From: Sarah Burrow <Sarah.Burrow@arun.gov.uk>
Sent: 07 September 2022 15:53
To: Planning.Responses <Planning.Responses@arun.gov.uk>
Cc: Katie Sharp <Katie.Sharp@arun.gov.uk>; Paul Cann <Paul.Cann@arun.gov.uk>
Subject: RE: Planning Consultation on: AL/55/22/DOC

Engineers Comments Regarding Surface Water Drainage - Condition 10

Application No: AL/55/22/DOC

Registered: 25th May 2022
Site Address: The Grange Westergate Street Westergate PO20 3SQ
Grid Reference: 493982 104365
Description of Works: Approval of details reserved by condition imposed under AL/28/21/PL relating to conditions 3-schedule of materials and finishes, 5-Construction Management Plan, 6-protection of dwellings from noise and vibration from railway line, 8-covered and secure cycle parking, 9-level survey, 10-surface water drainage, 11-foul drainage system, 13-landscaping, 15-Landscape and Ecological Management Plan and 16-electric vehicle charging points.

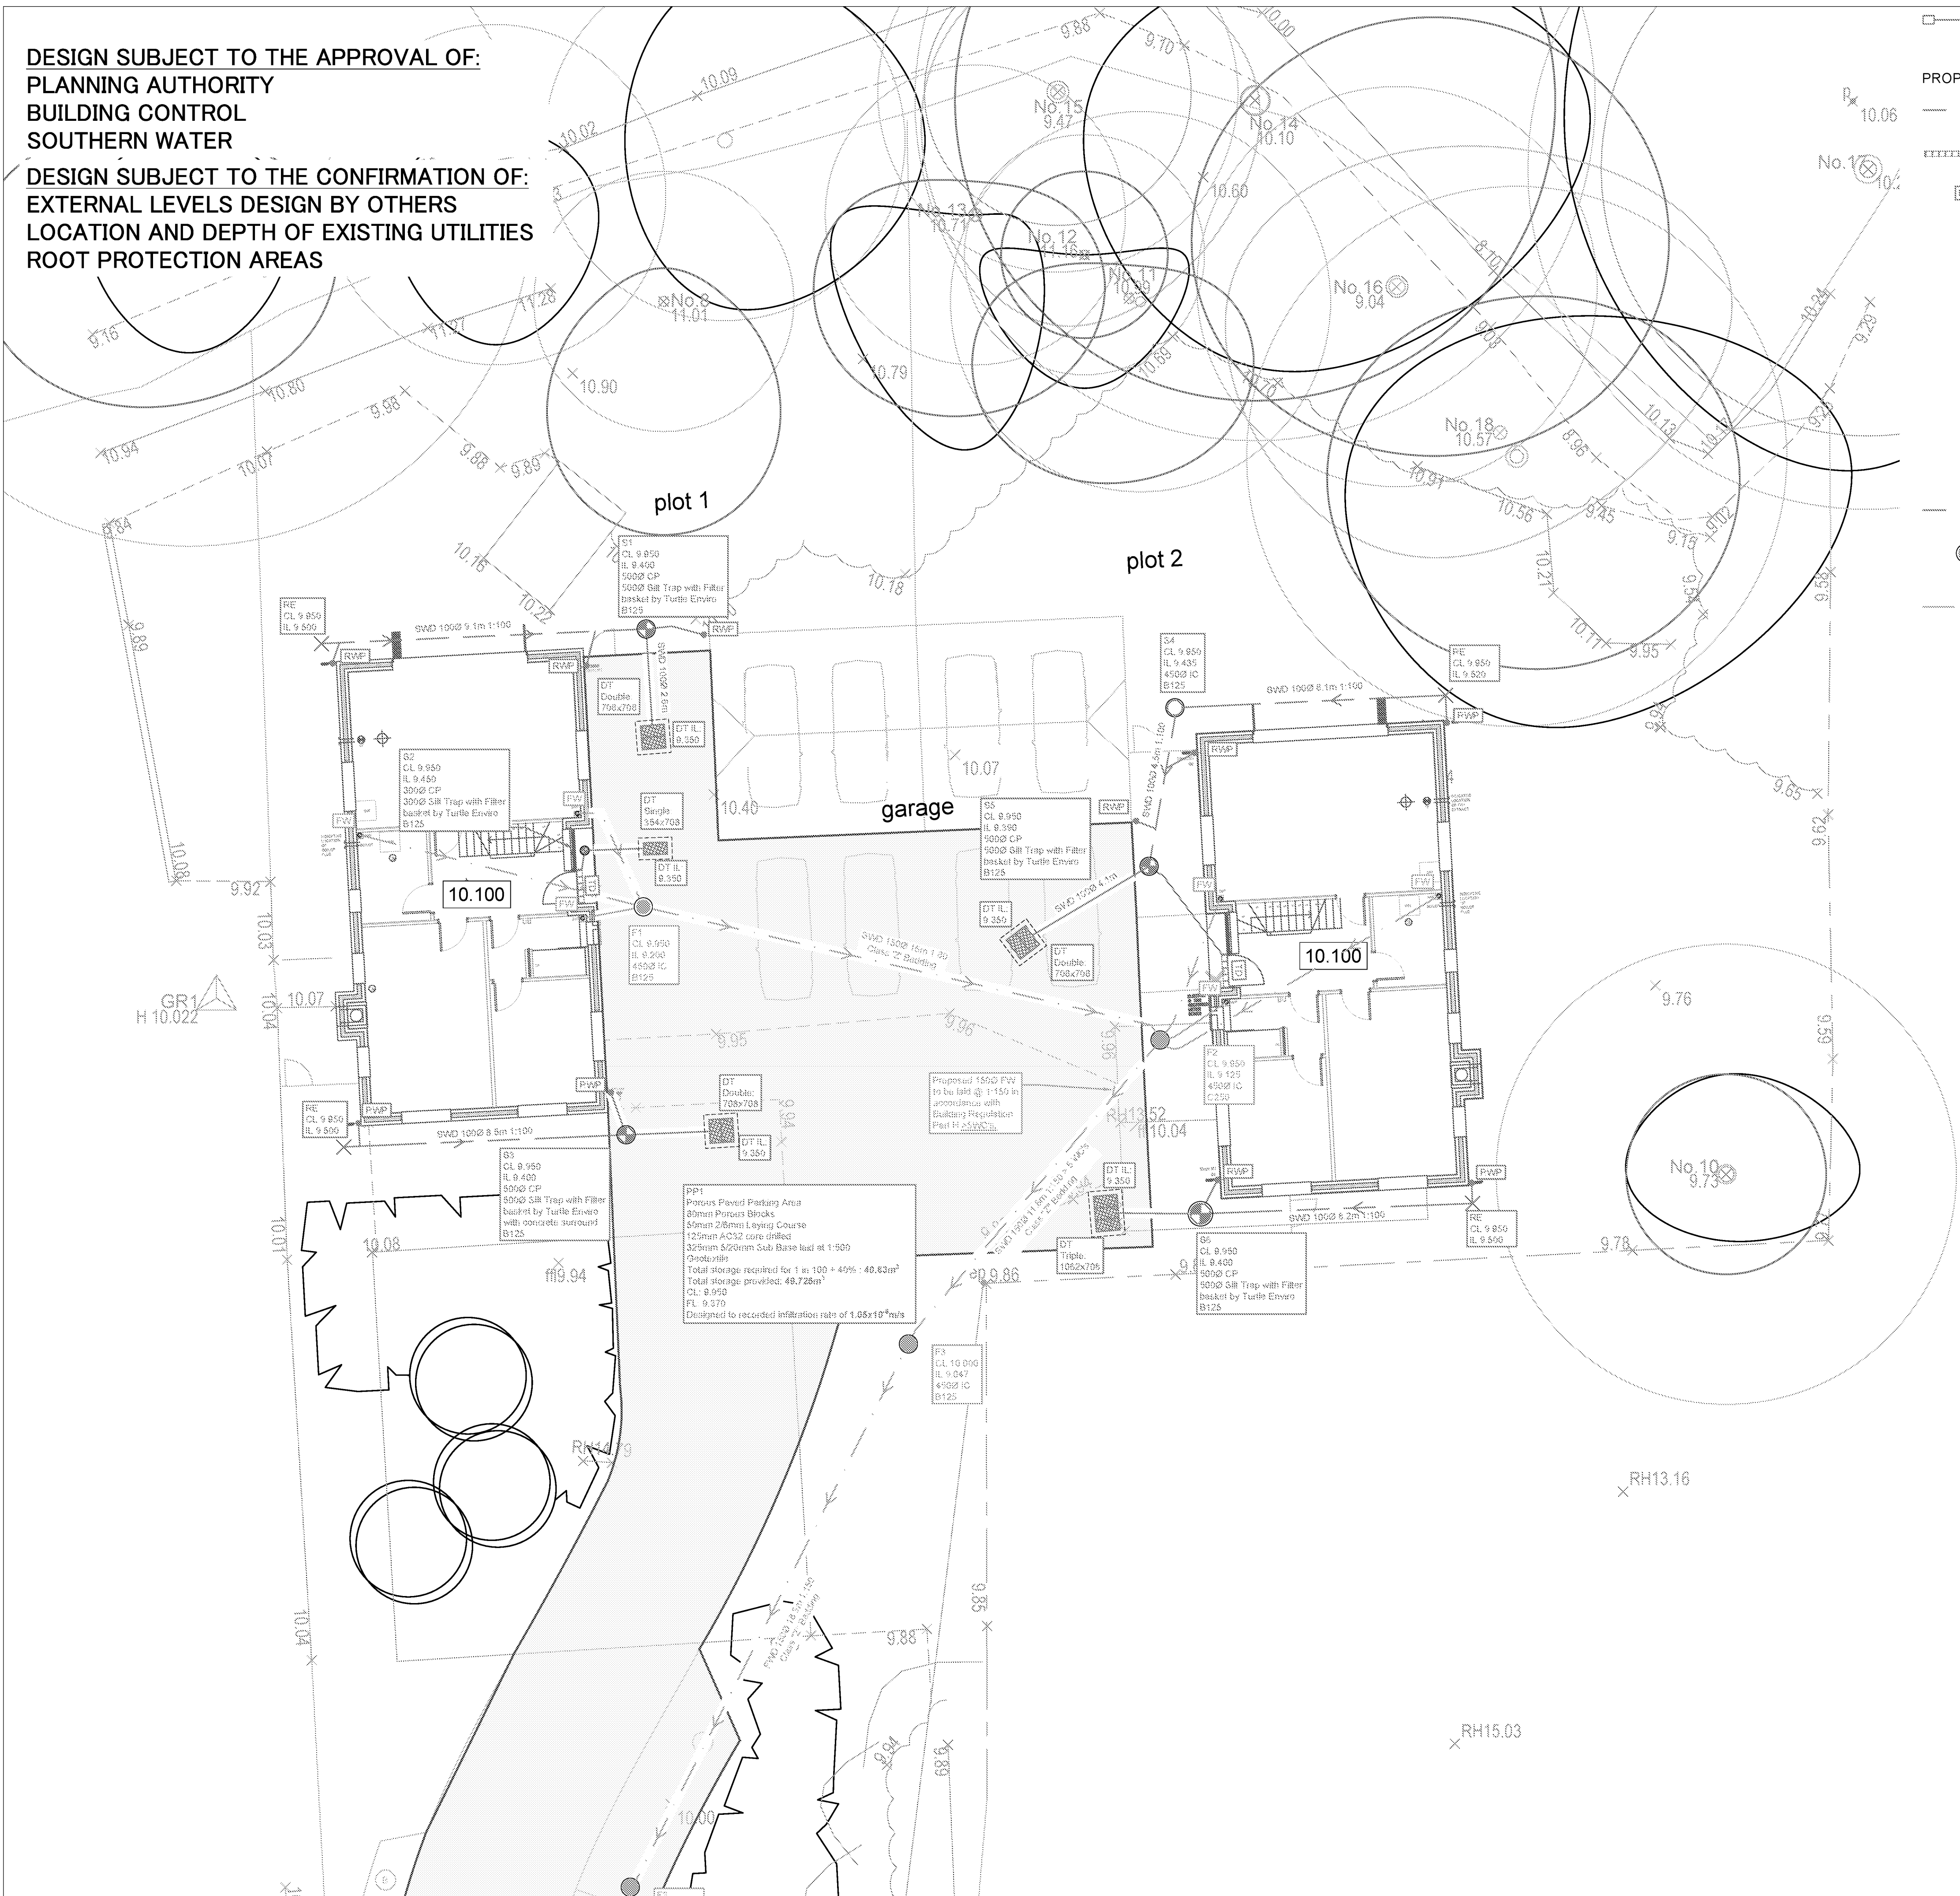
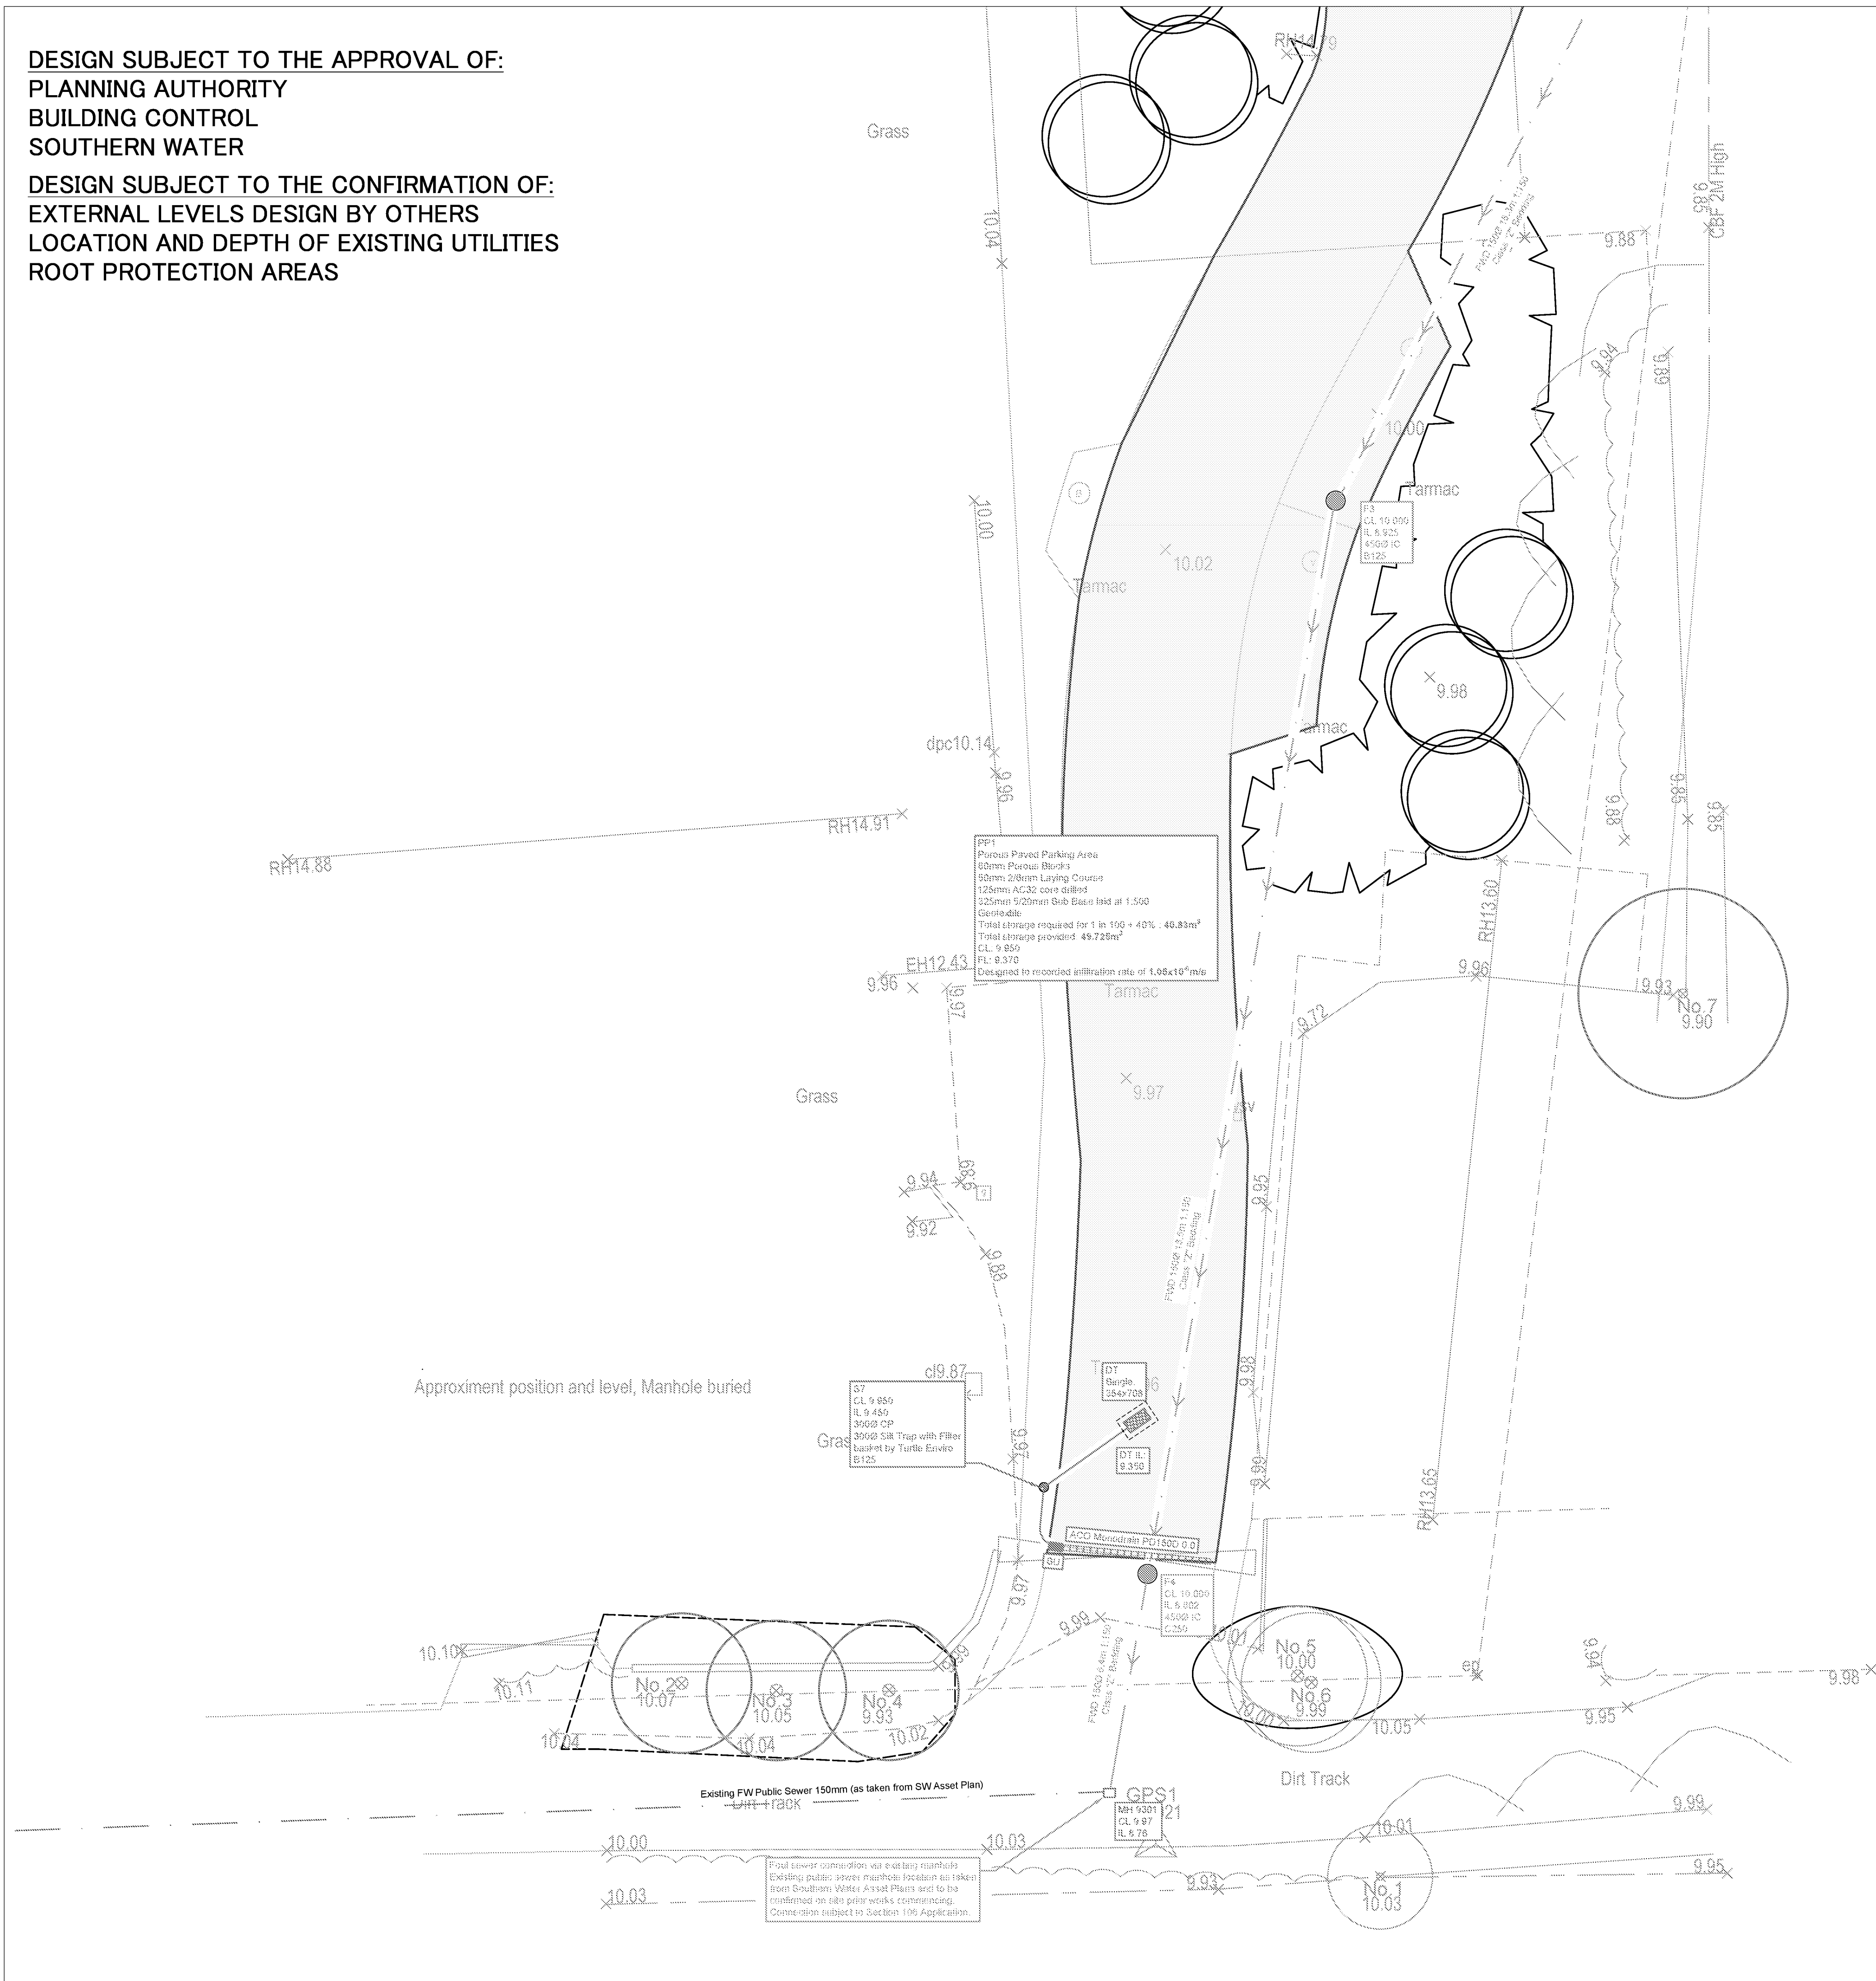
1. The infiltration rate calculations use an ap50 value of 0.93m². This value should be 1.08m² on the basis of the trial pit dimensions provided. The correct value will decrease the infiltration rate for the design. Please adjust accordingly.
2. Please include a scale bar on the drainage layout so impermeable areas and diffuser distances from structures can be checked. Alternatively please show measurements for the same purpose.

- g. Please supply the calculations for the 1 in 10 year + 40% event.
- h. The permeable paving invert level is set to 0.380, yet formation level is shown as 9.370 on the drainage layout. The value of 9.370 corresponds with the formation shown in the construction details, therefore please correct the calculations to reflect this.

- i. Slope is listed as 1:800 but on the drainage layout it is stated that sub base is laid at 1:500. Please correct.
- j. The safety factor can be reduced to 3 on the basis of minor inconvenience (surface water on carpark) as a consequence of failure, with a Cv of 1 for an impermeable area of <1000m².

- a. Please include pipe gradients.
- b. Diffuser blocks should be set above the 1 in 10 year +40% critical storm event. They are currently set below the formation level of the permeable paving (diffuser inverts at 9.350 – permeable paving formation at 9.370). These should also be located a minimum of 5m from all controlled structures, see point 3. Please correct.
- c. It is not clear why there are apparently random dotted lines on the drainage layout, please can their use be clarified or they be removed.
- d. Please detail sump depths for catchpits.
